THE NORTHERN BEACHES HOSPITAL (STAGE 2)

SUBMISSIONS / PREFERRED INFRASTRUCTURE REPORT

PROJECT REFERENCE: SSI 6792

9 April 2015

SECTION 1-1

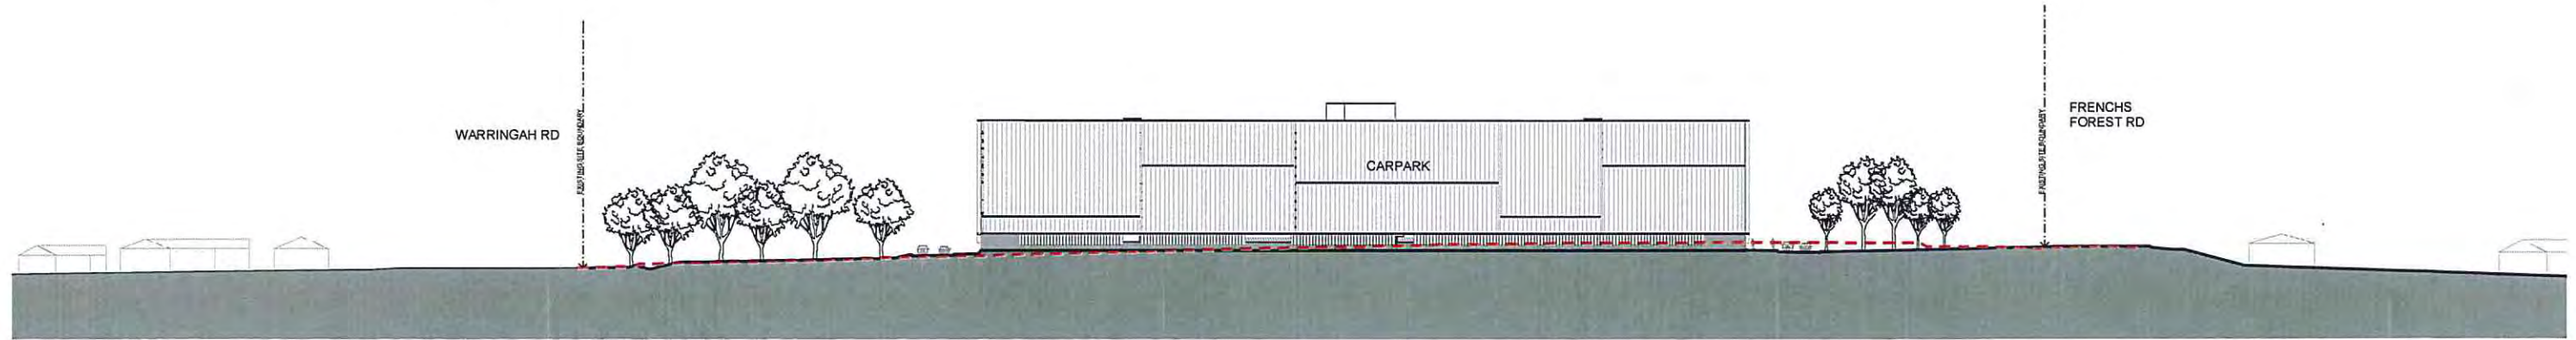
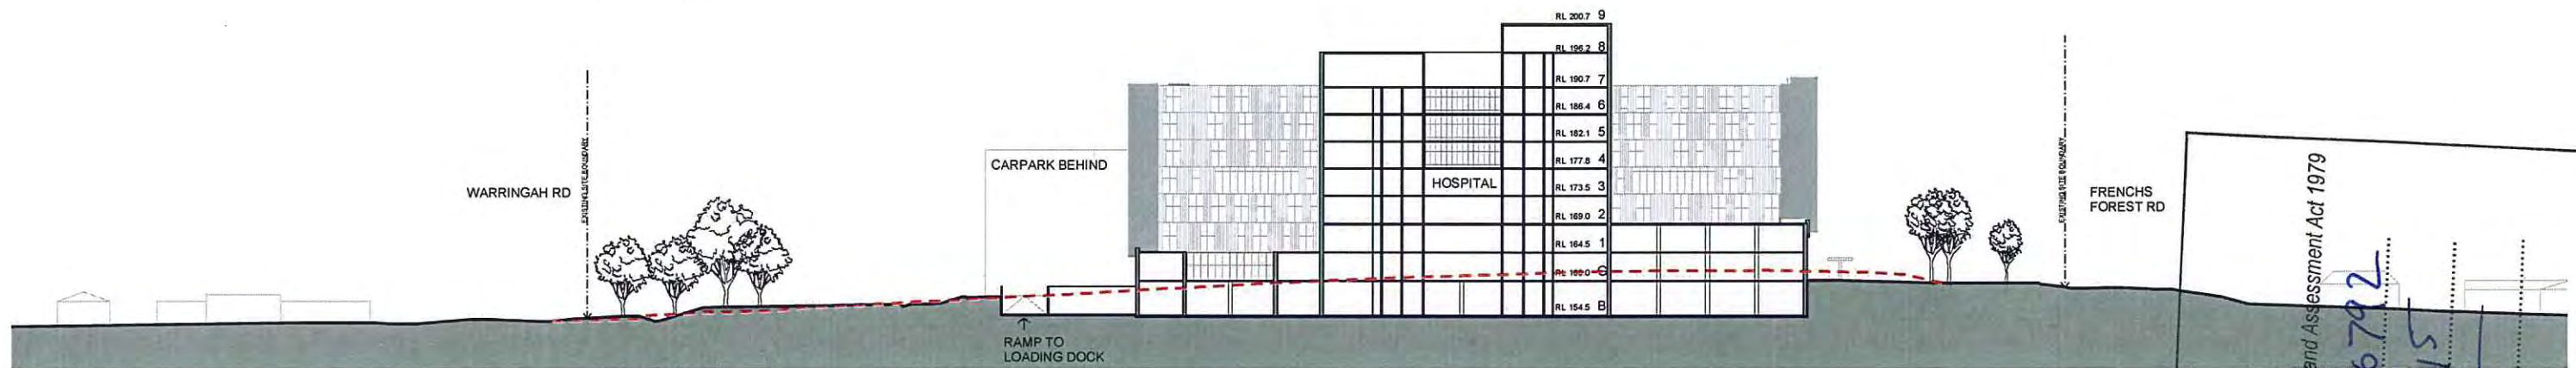
Comment	Response						
7. Motor Cycle Parking Consider providing motorcycle parking areas.	The need to provide motor cycle parking areas is referenced in the Car Park Plan (refer Appendix 2).						
8. Number of Beds and Treatment Spaces Provide clarification regarding the total number of beds and treatment spaces.	<table><tr><td>Total beds</td><td>488</td><td>*</td></tr><tr><td>Treatment areas</td><td>50</td><td></td></tr></table>	Total beds	488	*	Treatment areas	50	
Total beds	488	*					
Treatment areas	50						
9. Built Form and Urban Design Provide revised architectural and landscape plans that clearly illustrate the existing and proposed site levels for the entire site.	The Precinct Site Sections drawing (Figure 3) indicates the extent to which the proposed hospital responds to the existing land form and also highlights the proposed landscape treatment. The Precinct Plan (Figure 4) shows the location of the four sections that have been prepared. Section 1 is an east-west section that identifies The Forest High School site boundary, the carpark structure, the hospital, together with the proposed surface carpark and retaining wall structure immediately east of the hospital with the retained vegetation in the former Blinking Light Reserve extending to the Wakehurst Parkway. Three cross-sections AA, BB and CC are cut through the site from Warringah Road to Frenchs Forest Road West. Section AA is through the proposed carpark and identifies the extent of excavation required for the two basement parking levels.

Comment	Response
Provide additional images and a northern elevation landscape plan to illustrate the treatment along the northern boundary of the site.	Section BB is through the hospital and highlights the extent of basement excavation and the ramp to the loading dock at the basement level. Section CC is immediately east of the hospital and shows the retaining wall structure to the Frenchs Forest Road West frontage identified in the Stage 1 Modification Application. The sectional drawings indicate that, with the exception of the retaining wall structures to the north-east quadrant of the building complex and the excavation associated with the hospital basement and the carpark structure, the finished ground levels are broadly consistent with the existing site levels. Figure 5 – Landscape Sections & Figure 6 – Landscape Plan (North-East Quadrant) provide updated information relating to the on-grade staff parking, proposed landscape treatment and the retaining wall structure immediately east of the hospital. Landscape Section 5 now correctly shows the relative levels of the staff carpark, the hospital basement and the existing ground levels in the former Blinking Light Reserve. Figure 7 is a detailed drawing illustrating the northern elevational landscape treatment to Frenchs Forest Road West. The drawing is based on the Stage 2 landscape plans and the submitted planting schedules.
